From: Sarah Burrow <Sarah.Burrow@arun.gov.uk>
Sent: 15 July 2021 14:04
To: Planning.Responses <Planning.Responses@arun.gov.uk>
Cc: Simon Davis <Simon.Davis@arun.gov.uk>; Paul Cann <Paul.Cann@arun.gov.uk>
Subject: RE: Planning Consultation on: AL/75/21/PL

Engineers Comments Regarding Surface Water Drainage

Application No: AL/75/21/PL
Registered: 15th June 2021
Site Address: Lidsey Lodge Farm Sack Lane Lidsey PO22 9PE
Grid Reference: 494551 102604
Description of Works: Demolition of large agricultural buildings, removal of concrete yards and access, erection of 4 No.2 bed houses, 2 No. 3 bed houses, 2.No. 4 bed houses, gardens, access, parking, soft landscape and ecology areas. (resubmission following AL/27/21/PL). This application is a Departure from the Development Plan and is in CIL Zone 3 and is CIL Liable as new dwellings.

Project Name: Lidsey Lodge Farm
Drawing: Site layout and block plan
Drawing Number: 2020/10/11

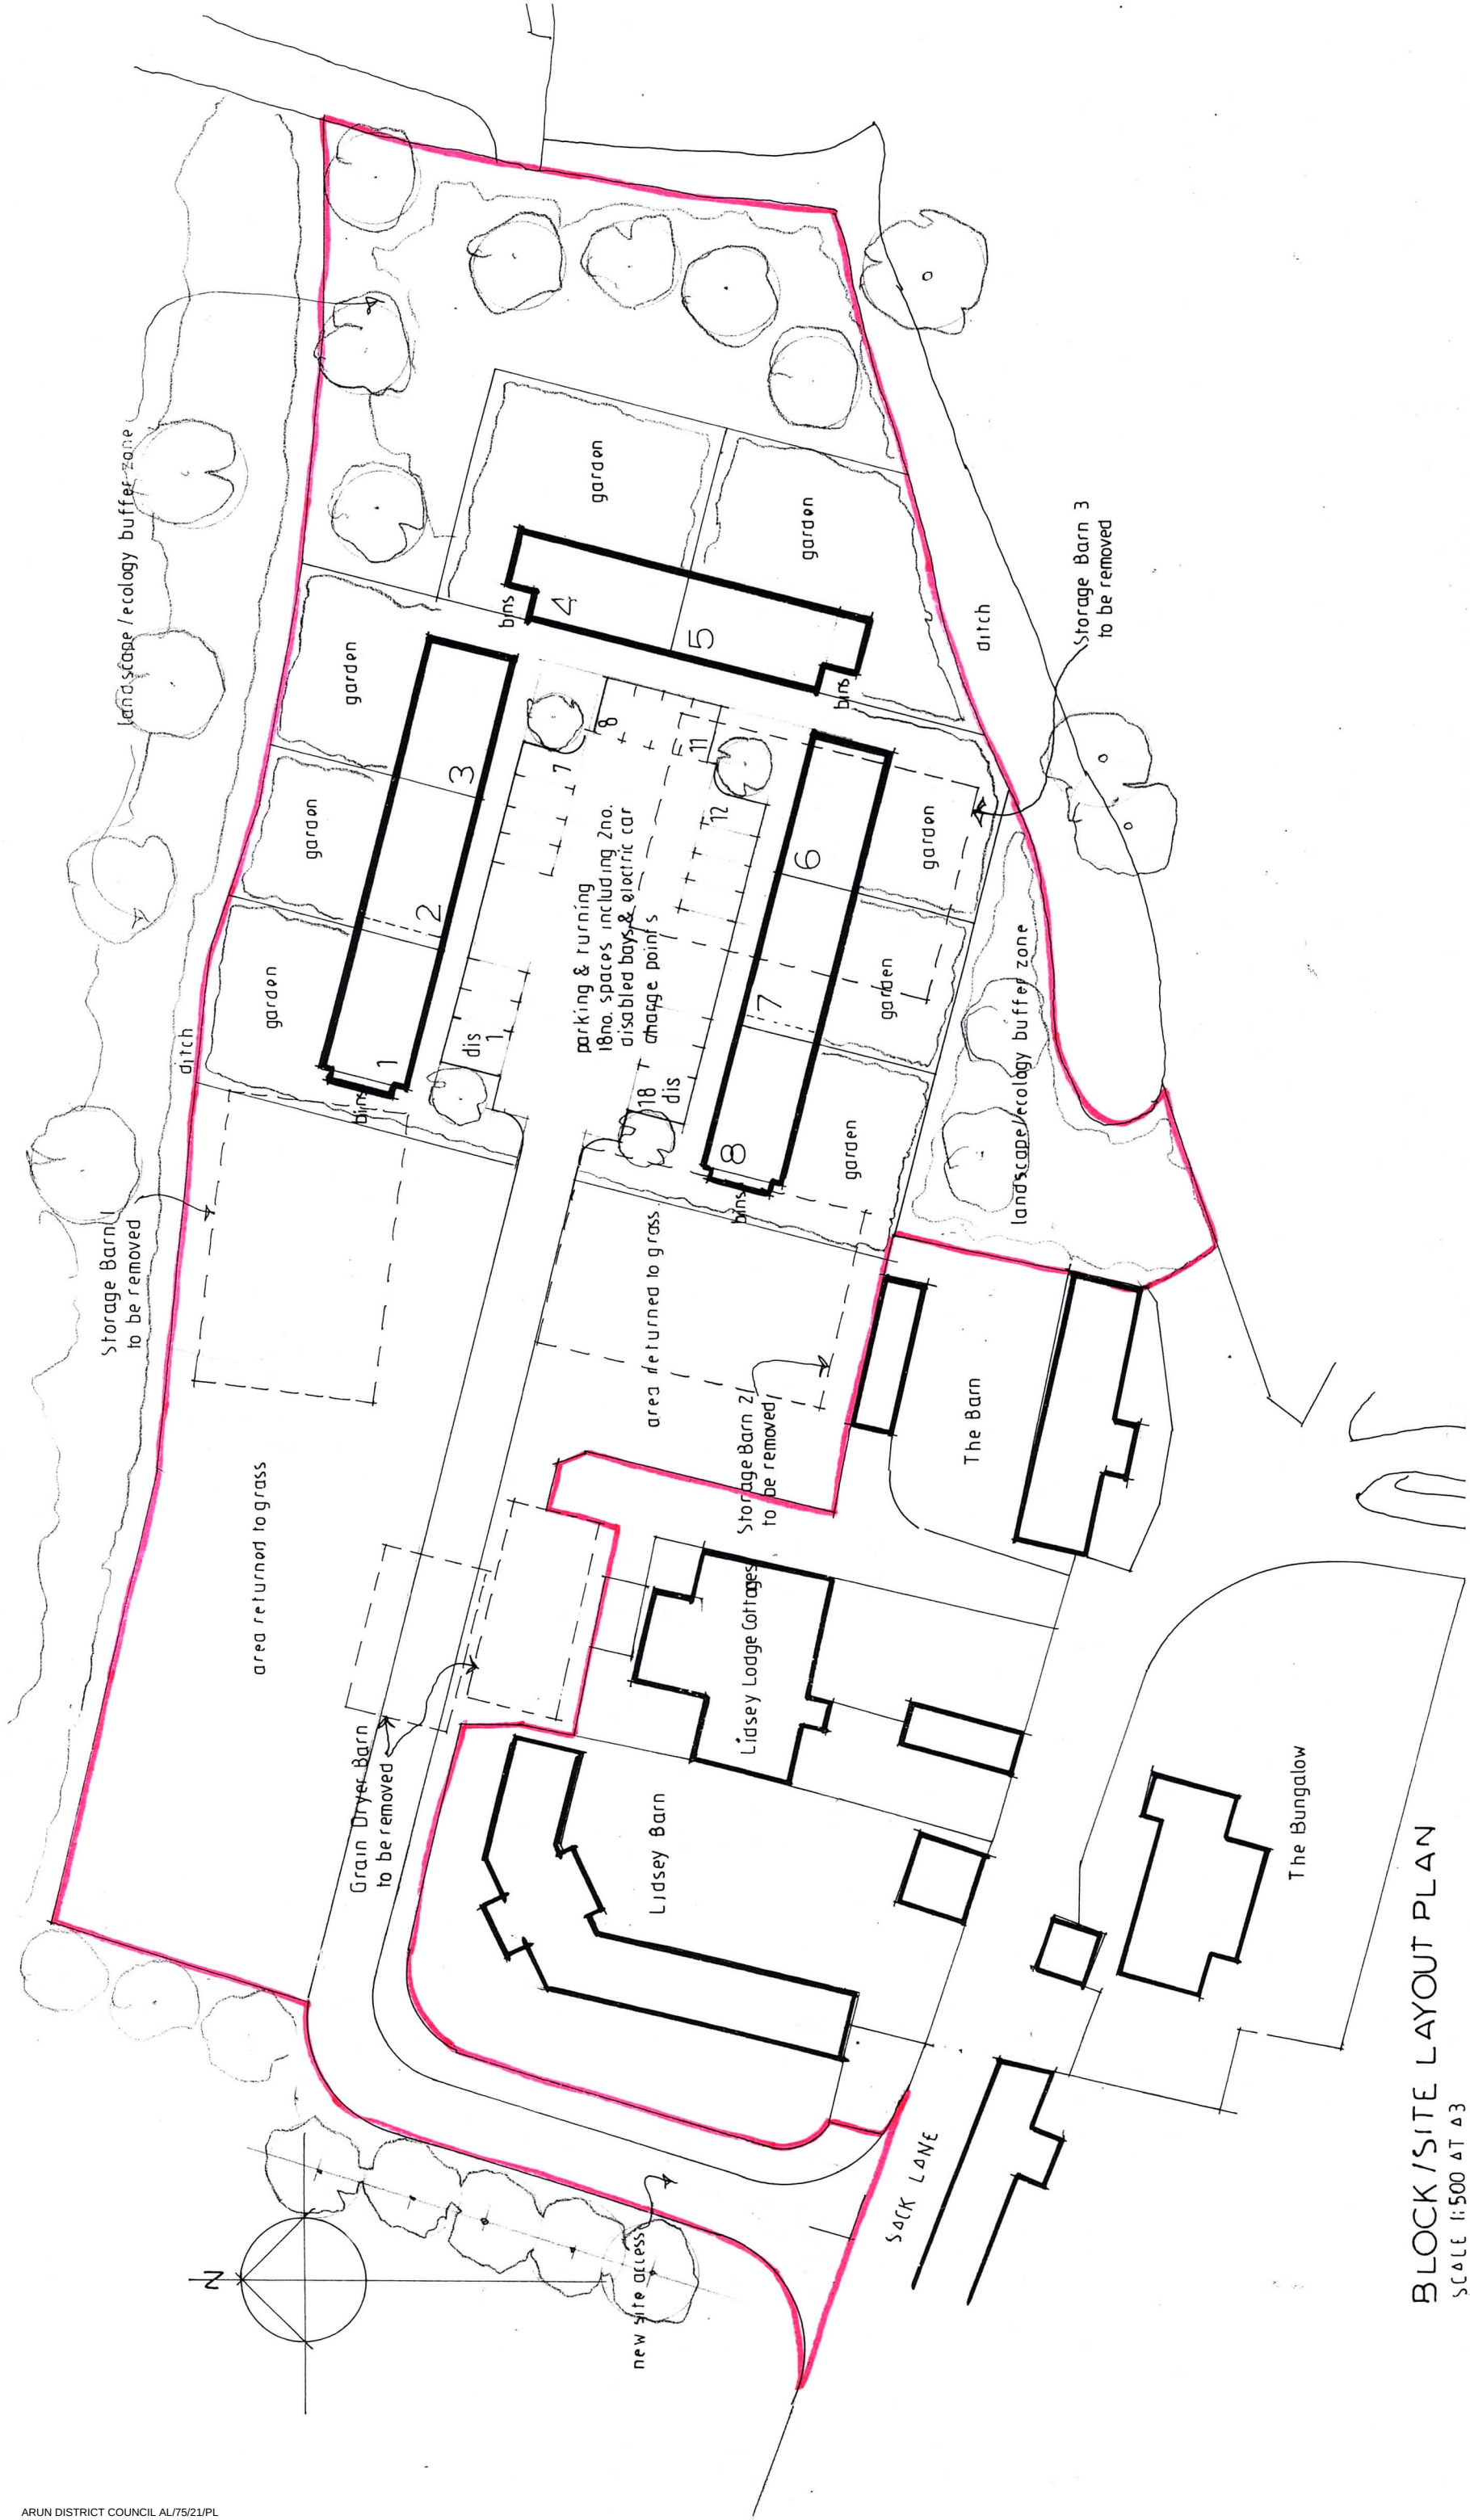
Assuming that infiltration is found to not be viable on the site, then the applicant proposes to dispose of surface water via permeable paving which provides water treatment and storage before discharging at a restricted rate of 2l/s to the watercourse at the north of the site. We are agreeable to this solution, as groundwater did not peak above 0.75mbgl we would like to see the permeable paving lined with a permeable liner to make use of whatever limited infiltration potential there may be on the site.

Site investigations will be necessary to investigate the condition of the receiving watercourse and it is likely that remedial works will need to be carried out to this watercourse to ensure that it is capable of taking the flows proposed. Please contact Paul Cann of this department to organise a site visit so that he can discuss any works that may be required and the requirements for the Ordinary Watercourse Land Drainage Consent which will need to be applied for, for authorisation to make a connection to the ditch.

The applicants engineers are aware of the required easements to the watercourse as these are cited within the FRA. Please ensure that not only buildings, but also boundary fences are not sited within 3m of the watercourses. Please provide a plan showing the buffers and the flood zones when a Discharge of Conditions application is made (if this application is approved).
